**CITY OF ALBUQUERQUE
PLANNING DEPARTMENT
January 21, 2015
DRB Comments**

PROJECT # 1004223

APPLICATION # 15-70009

RE: Lot 6-B Sundt's Ind Center & Parcel D of Renaissance 3

PLAT OF  
**PARCEL D-1**  
**RENAISSANCE CENTER 3**

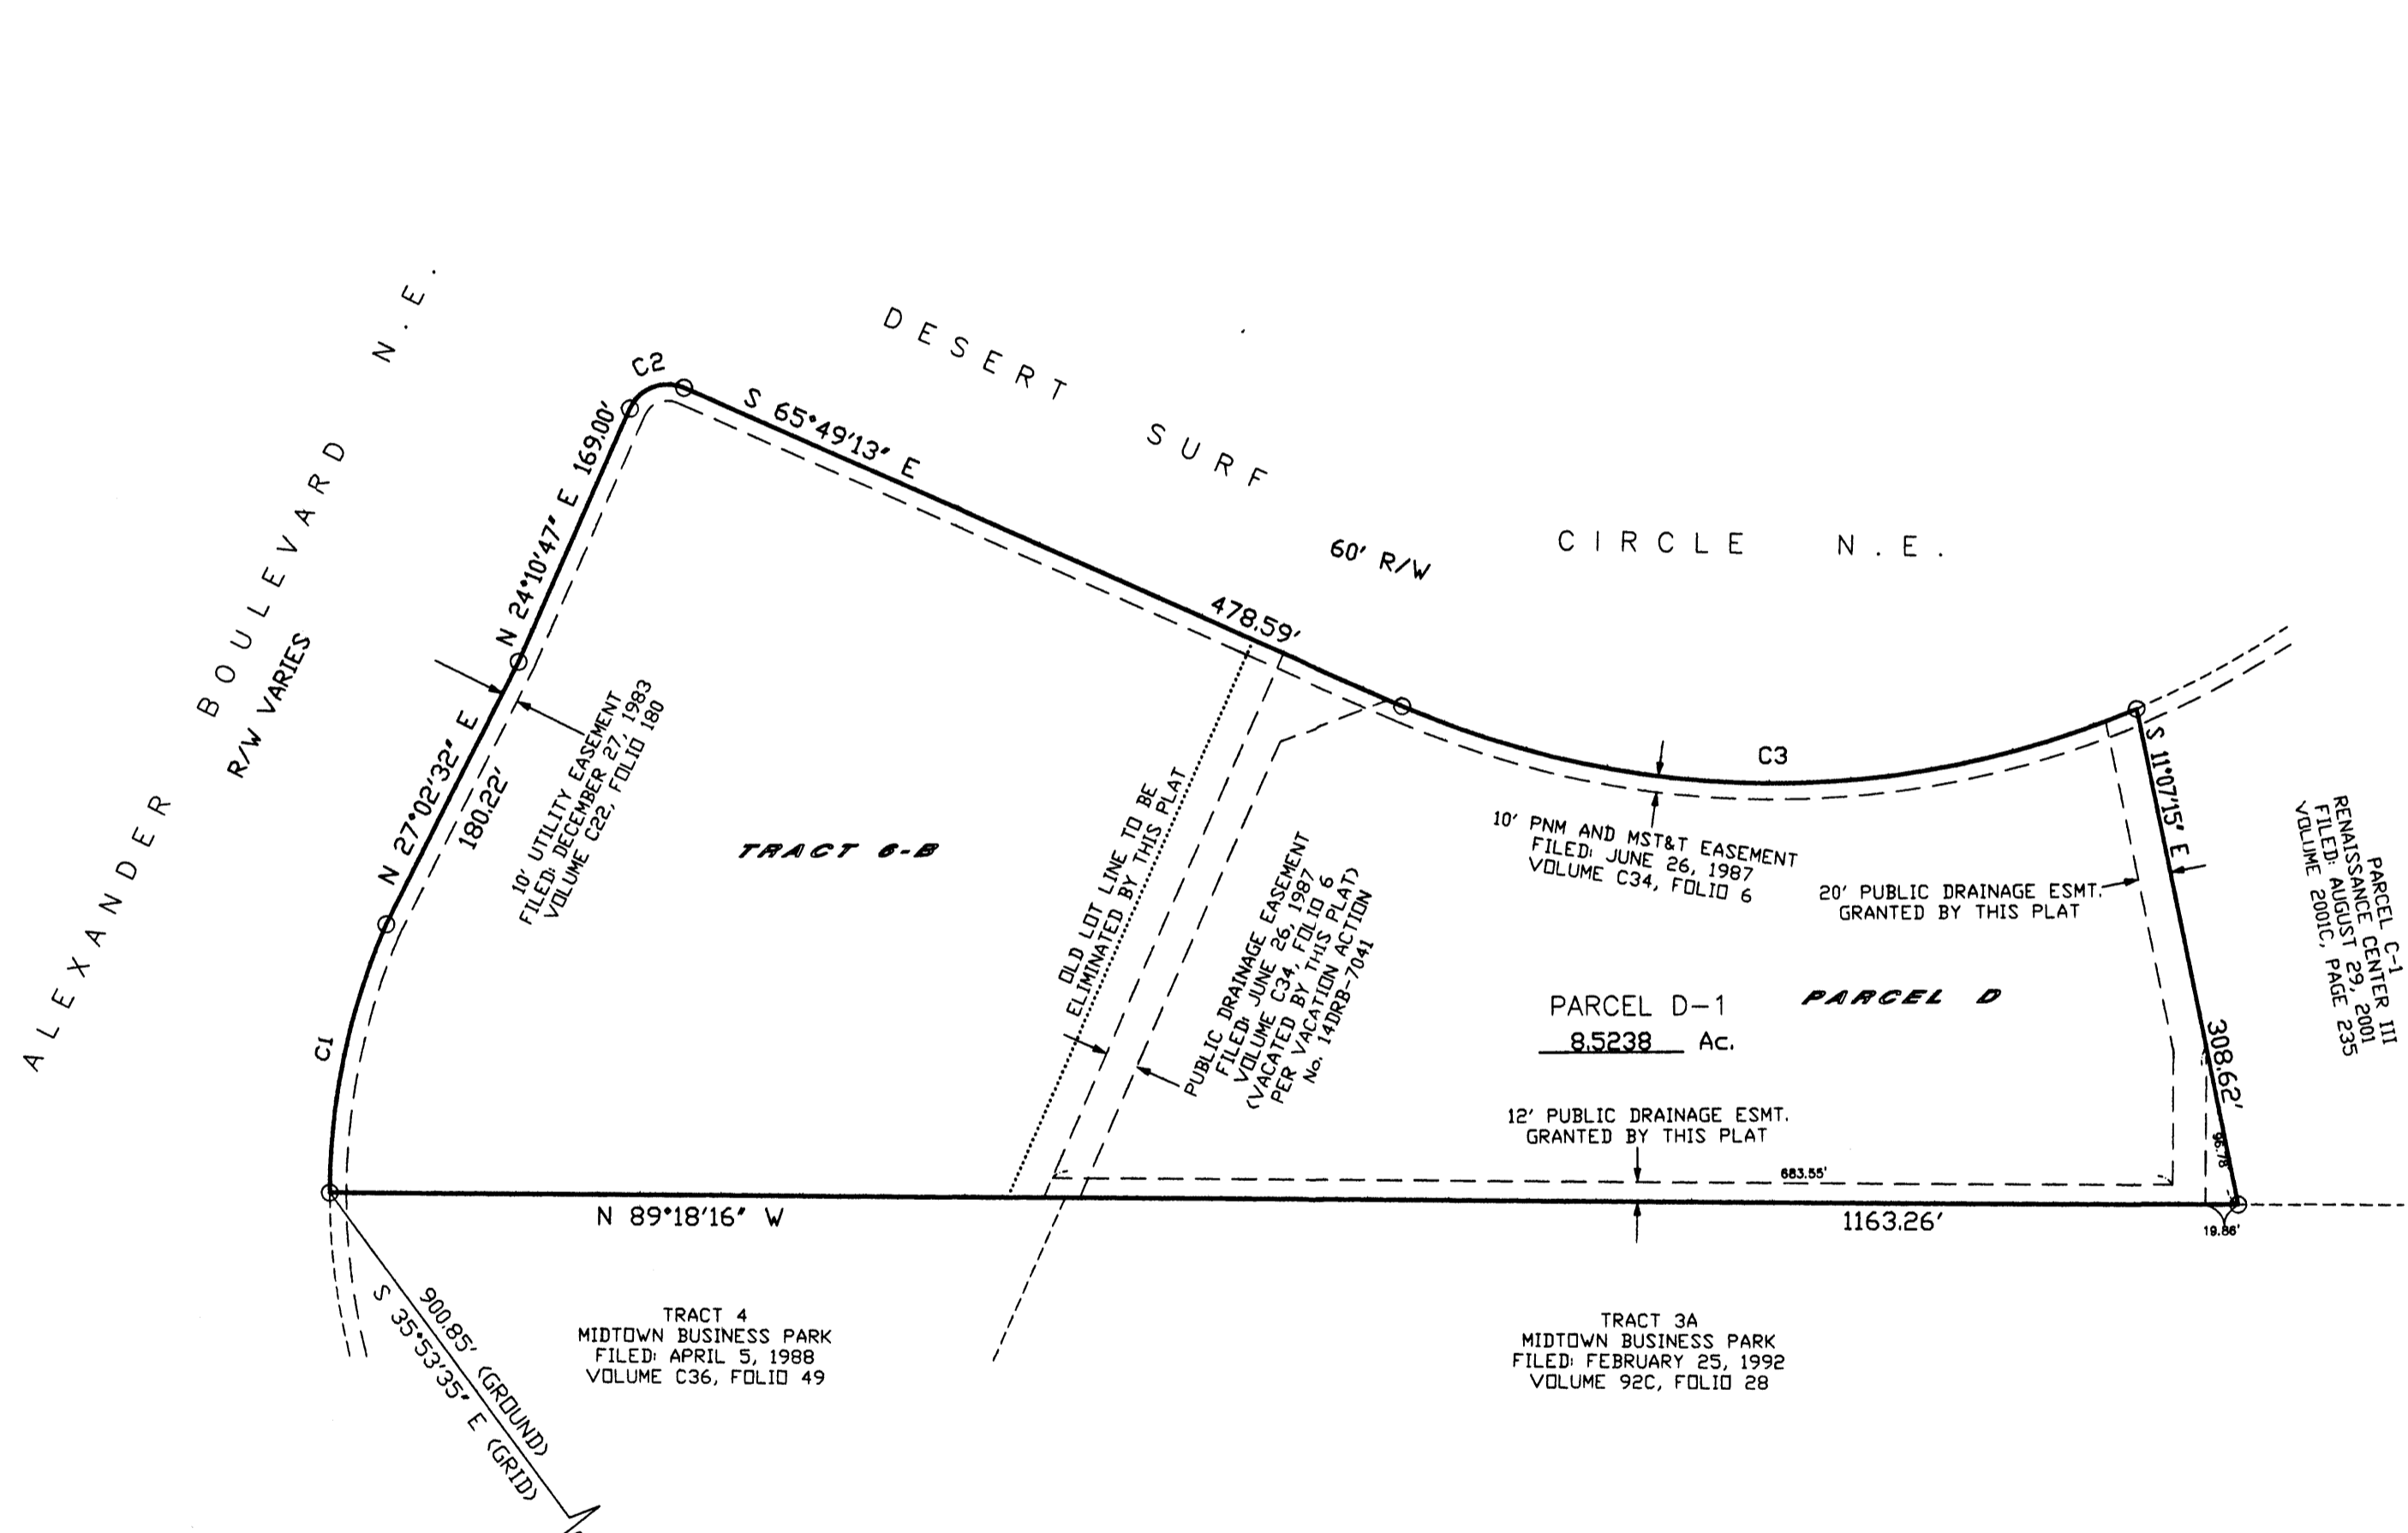
The referenced Vacation application number on the plat drawing (sheet 2) is incorrect; please refer to the respective vacation application, agenda and Official Notice of Decision.

# PLAT OF PARCEL D-1 RENAISSANCE CENTER 3

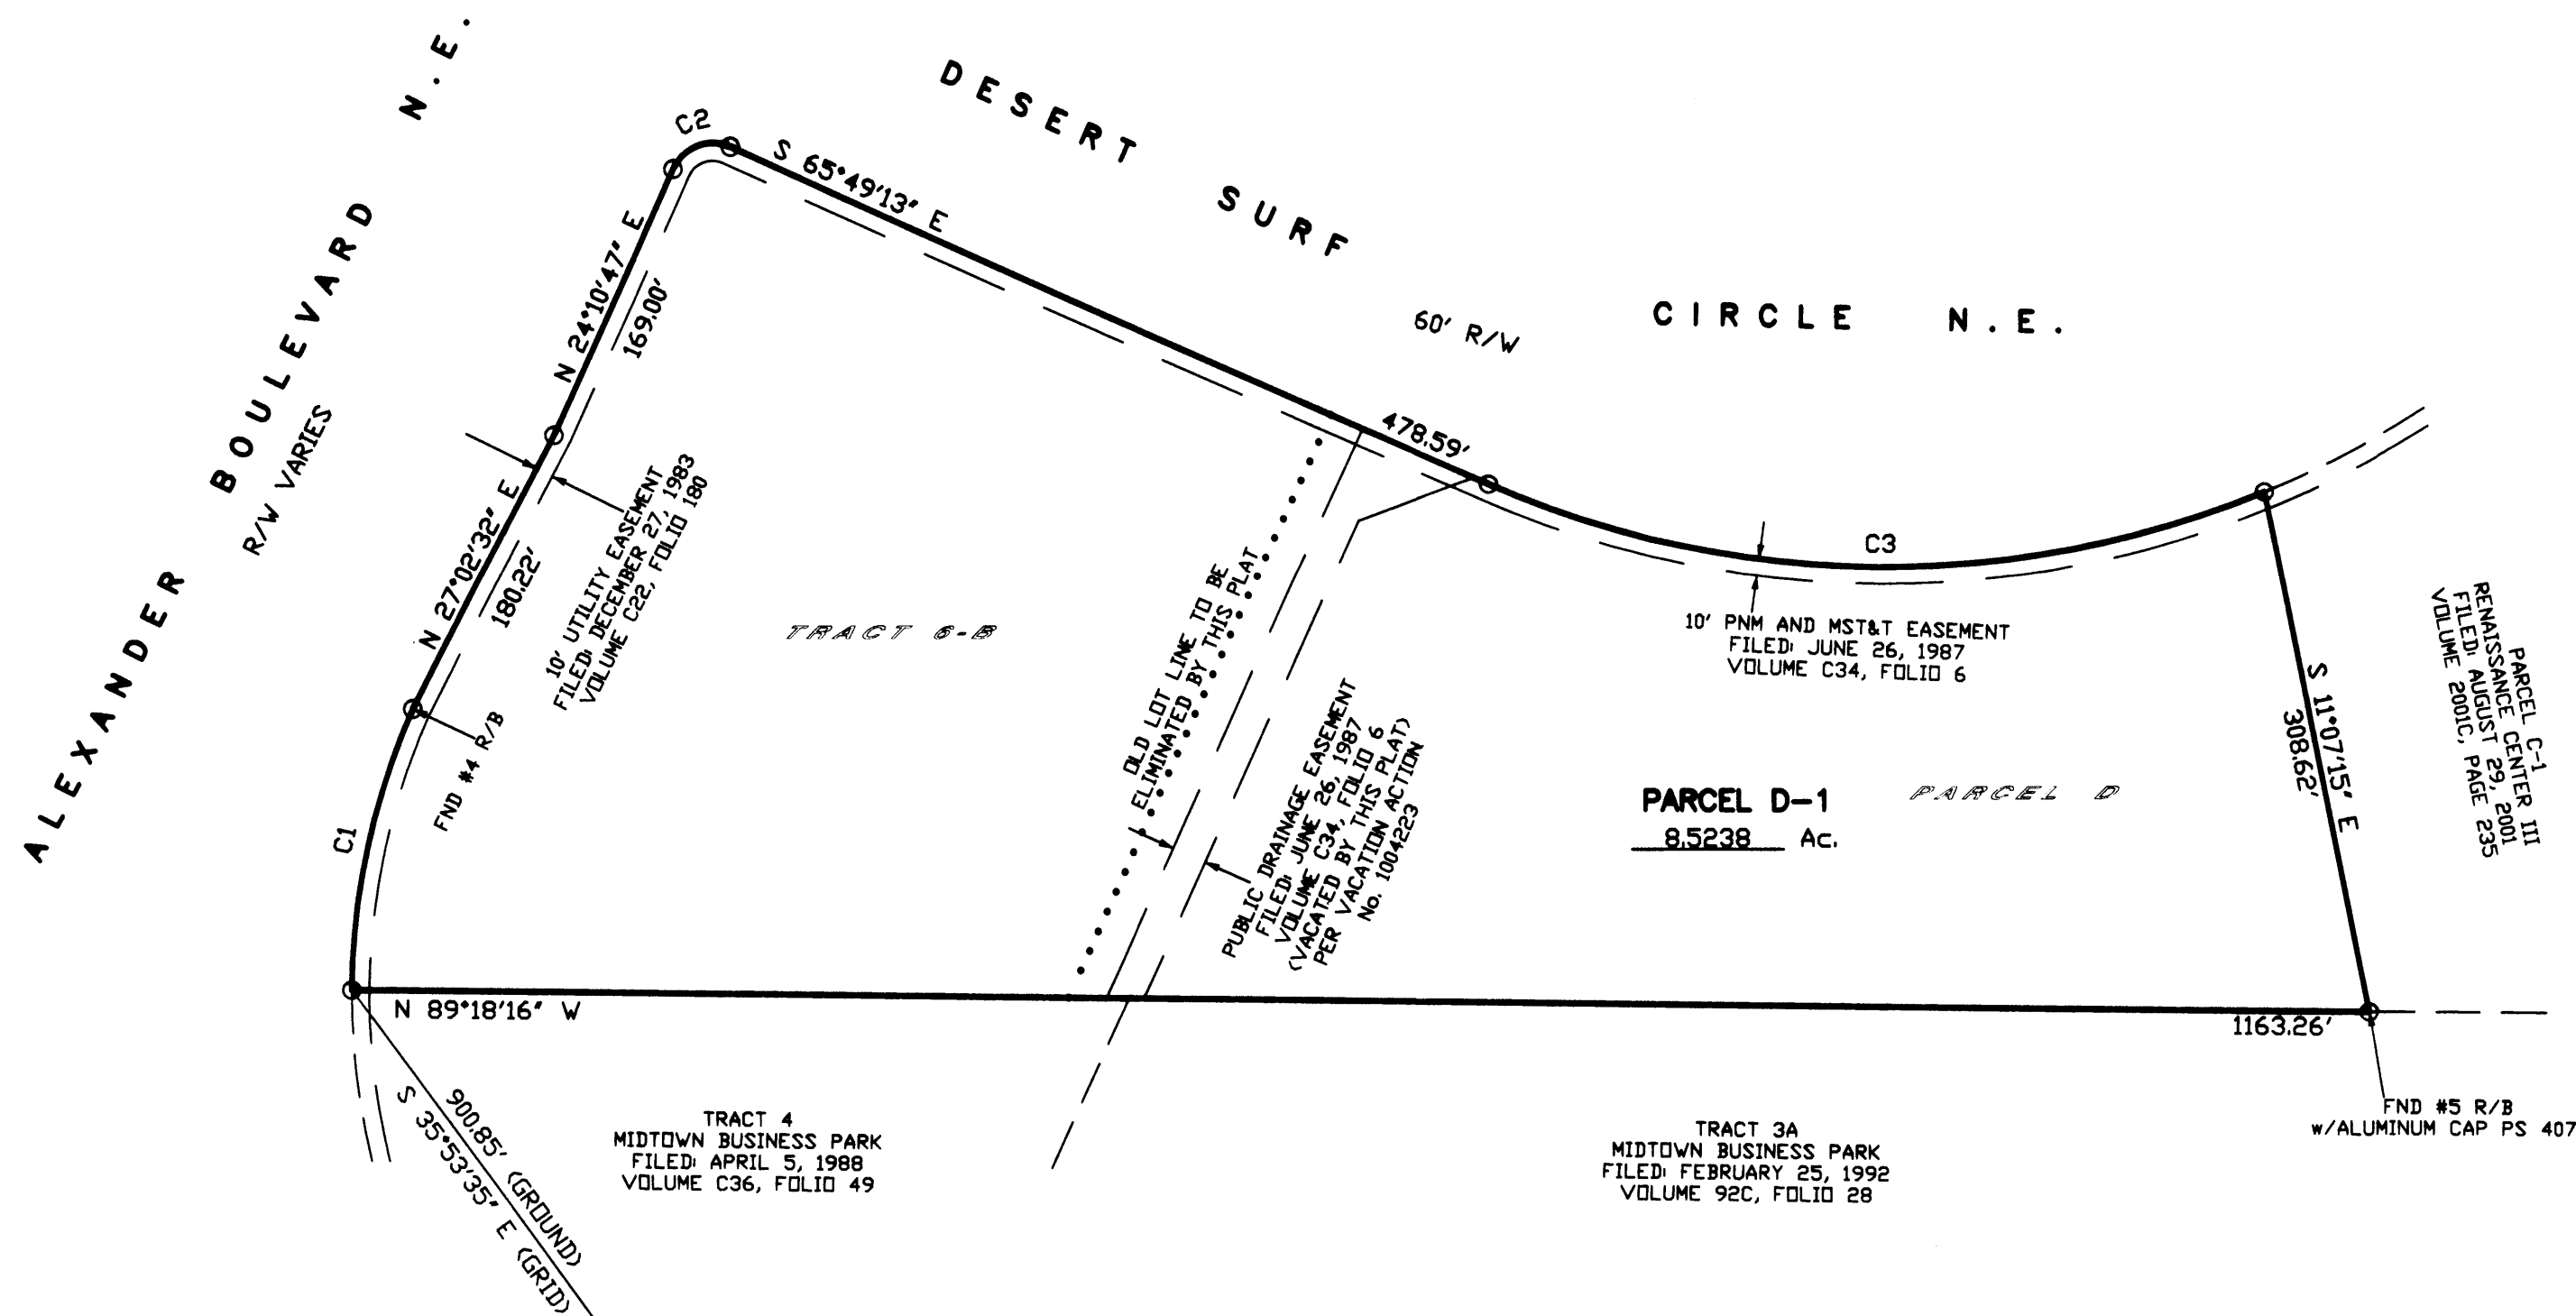
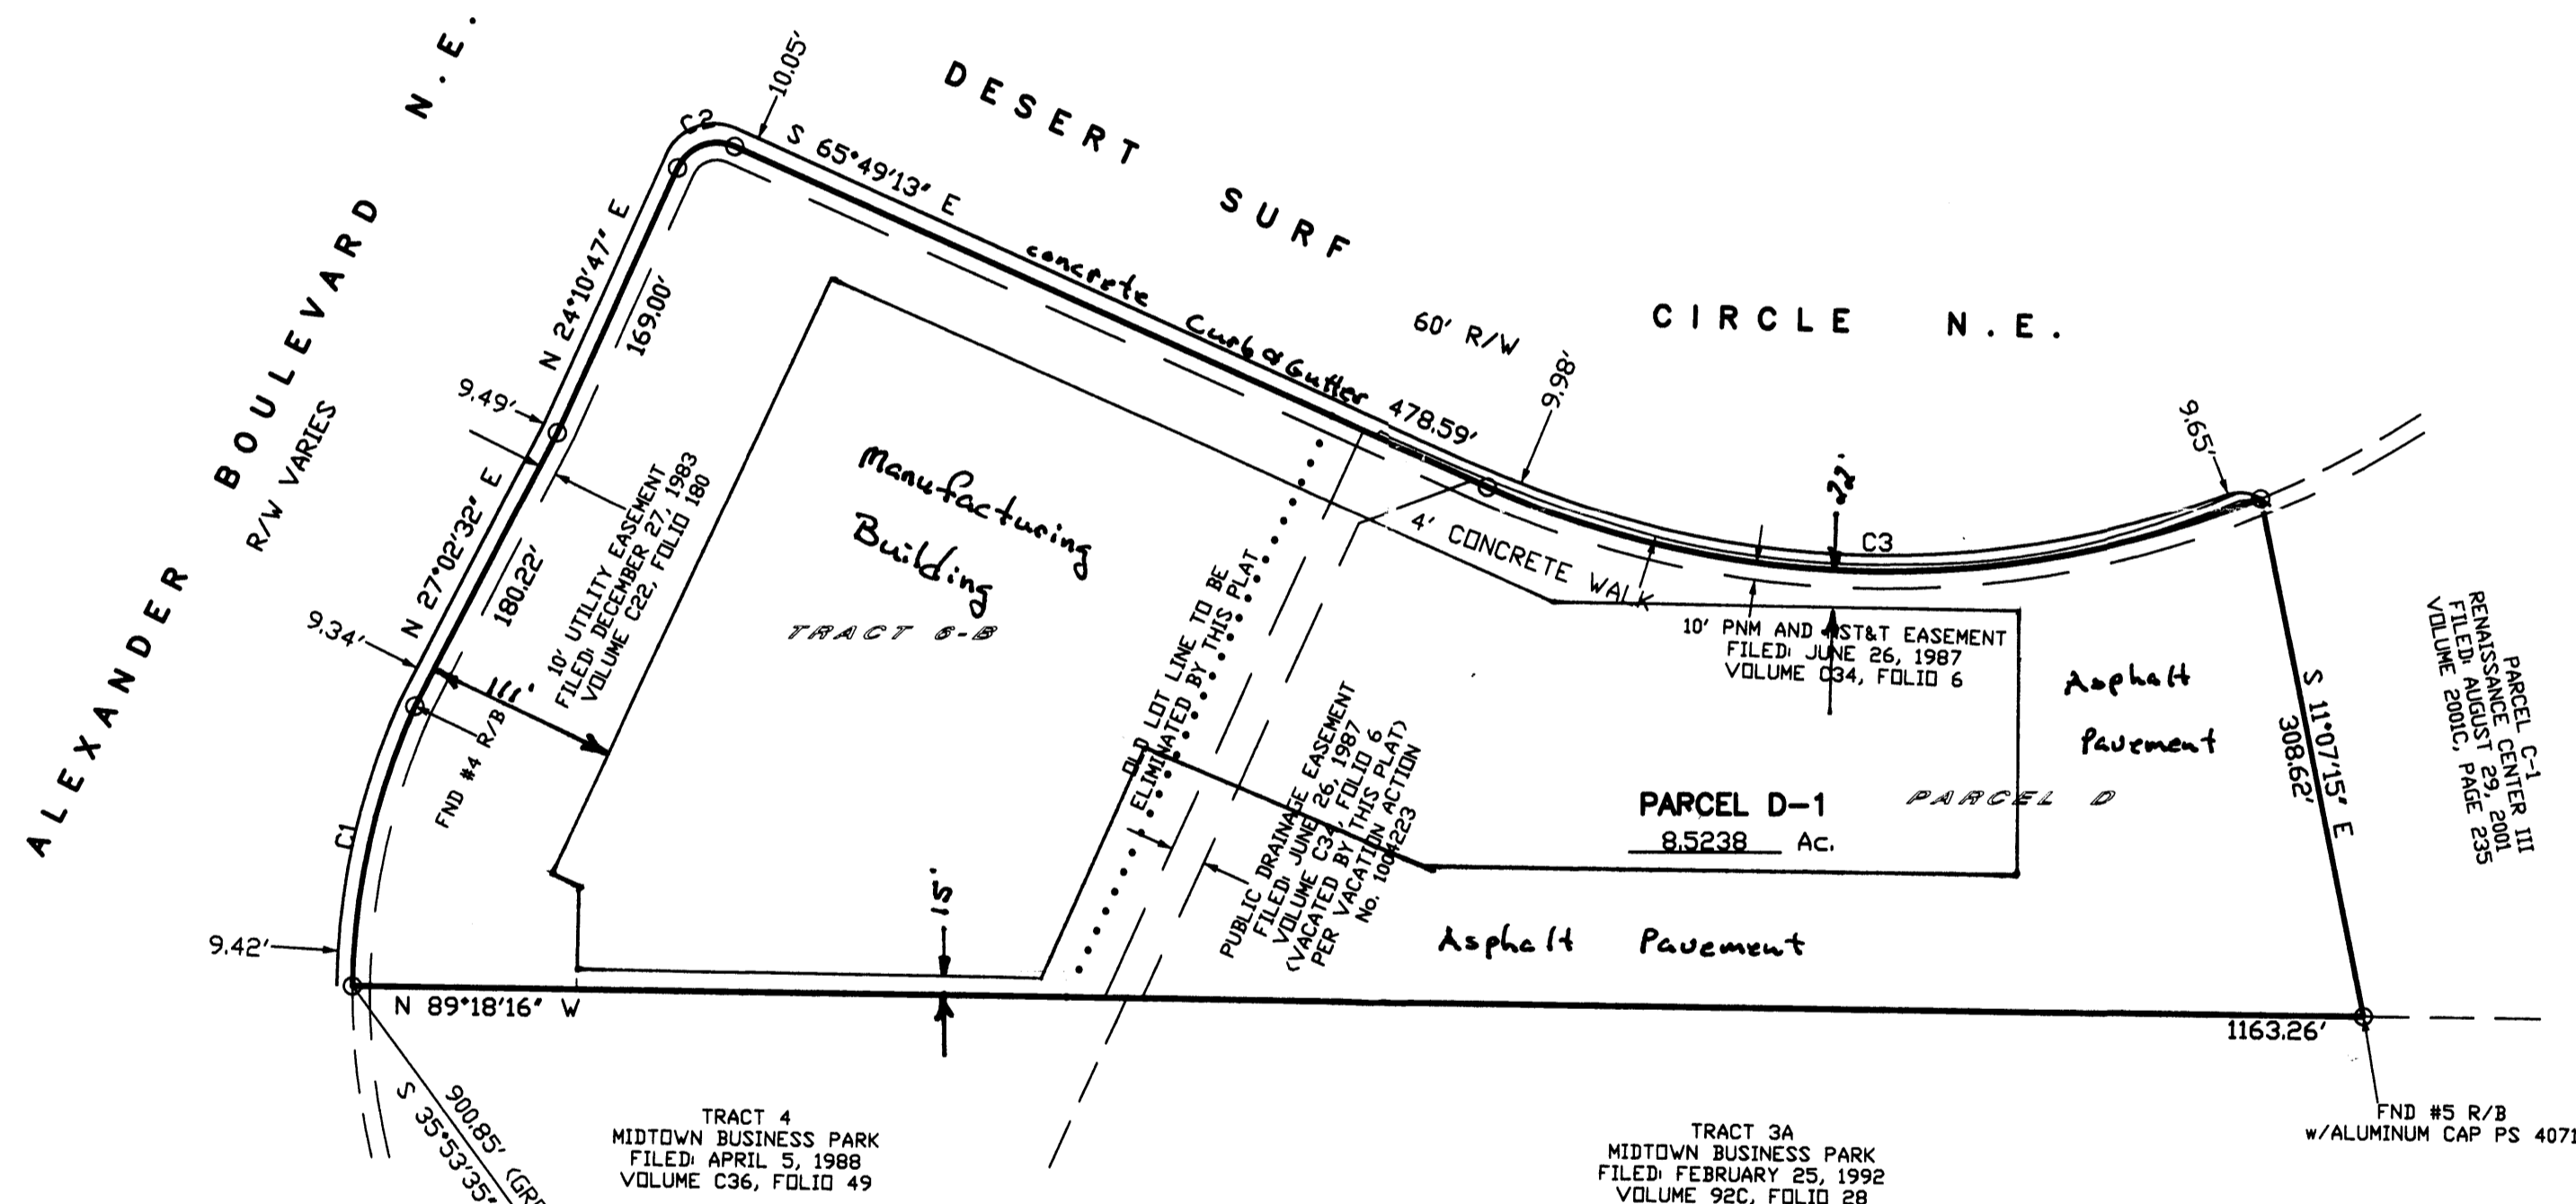
On the plat drawing, please reference the DRB Application Number for the vacation (12DRB-70349), not just the Project Number.
